**Response to amended/additional material - State Significant Development (SSD-80432461) – Infill Affordable Housing at 2-6 Pilgrim Avenue and 11-13 Albert Road, Strathfield**

## **Strathfield Council Response to amended/additional material to State Significant Development (SSD-80432461) – Infill Affordable Housing Development**

Figure 23 Ground Floor Landscape Plan

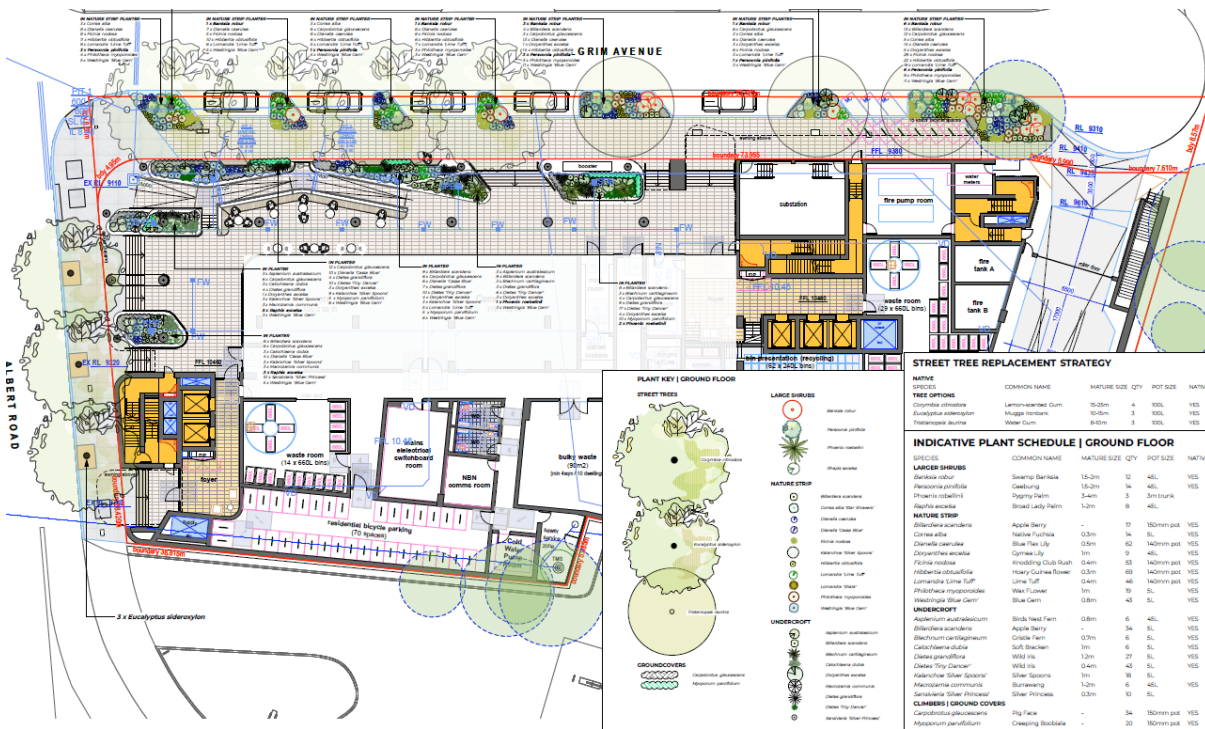
Council reiterates its previous advice regarding the retention and protection of Tree 2 (*Tristaniopsis laurina*) located on Pilgrim Avenue (SRZ 2.76m, TPZ 6.4m). The tree is in good health, provides significant canopy coverage, and does not overhang the development boundary. Current architectural/landscape drawings propose removal of Tree 2 to accommodate on-street parking.

Council strongly recommends integrating parking while retaining the tree, similar to examples such as Watsons Street, Neutral Bay, where raised permeable pavement parking spaces have been successfully incorporated with existing street trees.

Figure 36 Level 1 Affordable Housing Distribution and GFA

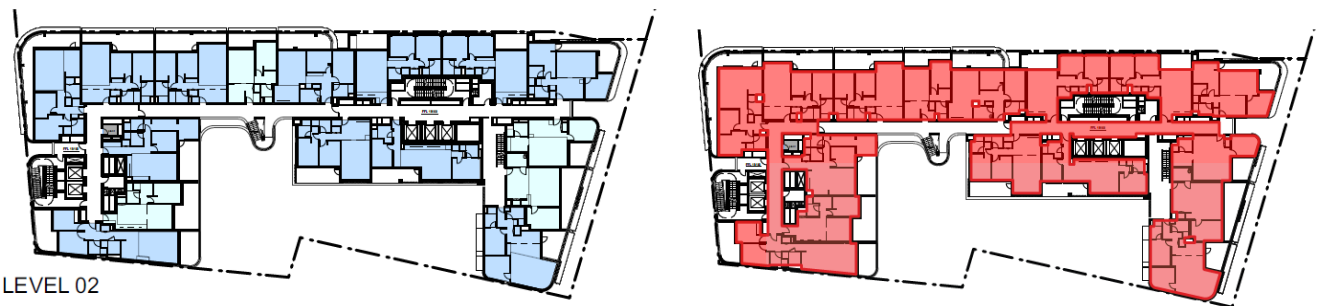
The inclusion of plenums for cross ventilation in corner units is illogical. These units are already considered cross-ventilated under the Apartment Design Guide (ADG), making the provision of plenums unnecessary.

Previous referral advice recommending the combination of internal corner units on Levels 1–3 to avoid the need for plenums has not been addressed.

Council does not support cross-ventilation via plenums. Council's suggested approach would be to convert the affected apartments into two-storey, 3+ bedroom units to achieve:

- a. Cross-ventilation (single-aspect two-storey units are considered cross-ventilated under the ADG)
- b. Increased proportion of 3-bedroom units. The current 7% provision falls short of the ADG minimum of 10%, the Homebush TOD mandate of 20%, and Strathfield Council's own strategic targets.

Figure 46 Borehole Locations

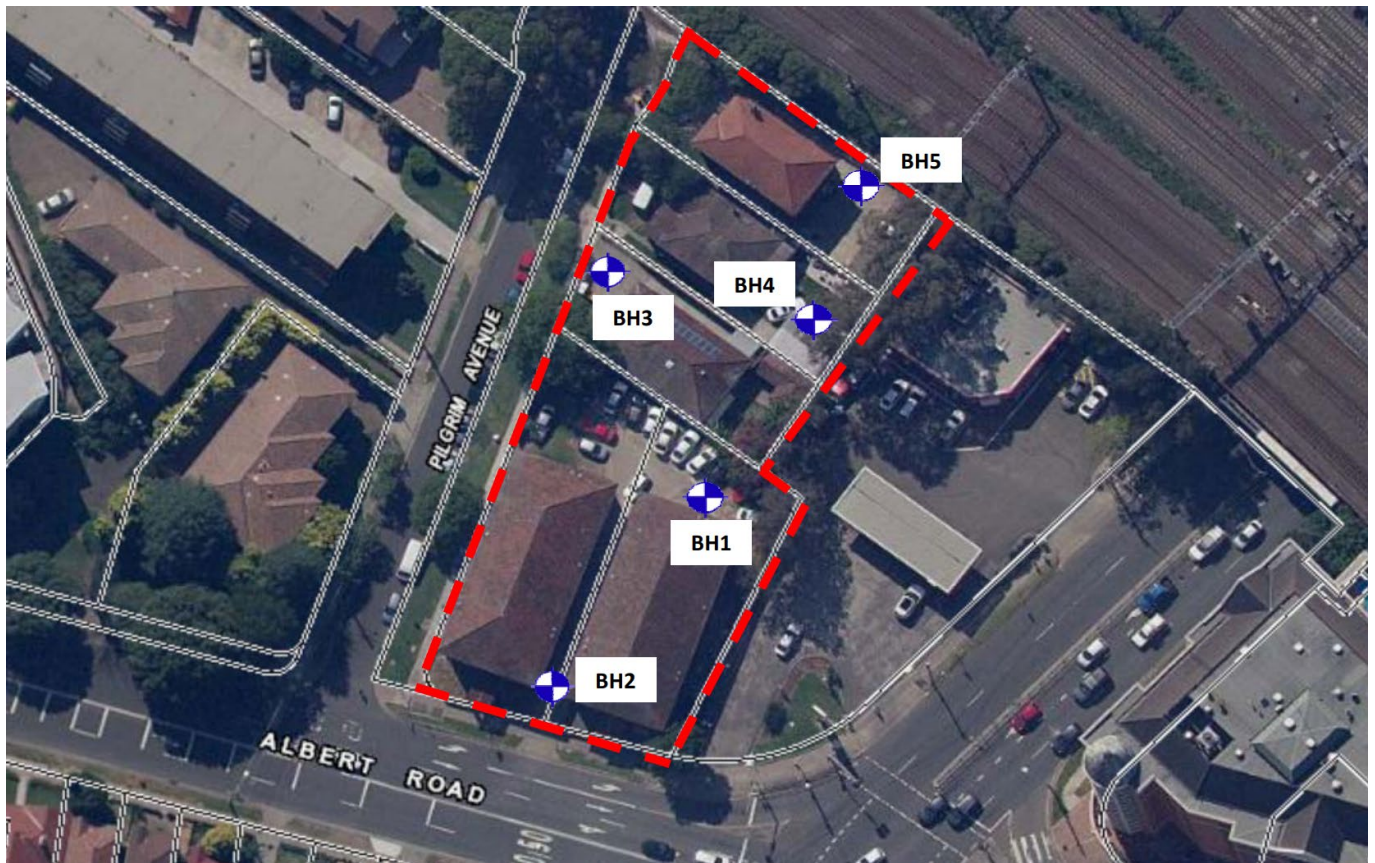
Access to the adjoining service station property was not obtained, and no intrusive investigations were undertaken close to the UPSS infrastructure. As a result, the highest-risk source area has not been investigated. Best practice under the NEPM and EPA guidance is that where direct access is unavailable, investigations should be conducted as close as possible to the shared boundary to assess the potential for off-site impacts.

The site comprises a total area of 3,361m<sup>2</sup>. The bulk excavation is to depths of approximately 14 metres below ground level. 4 boreholes and 2 groundwater monitoring bores targeting the boundary with adjoining service station.
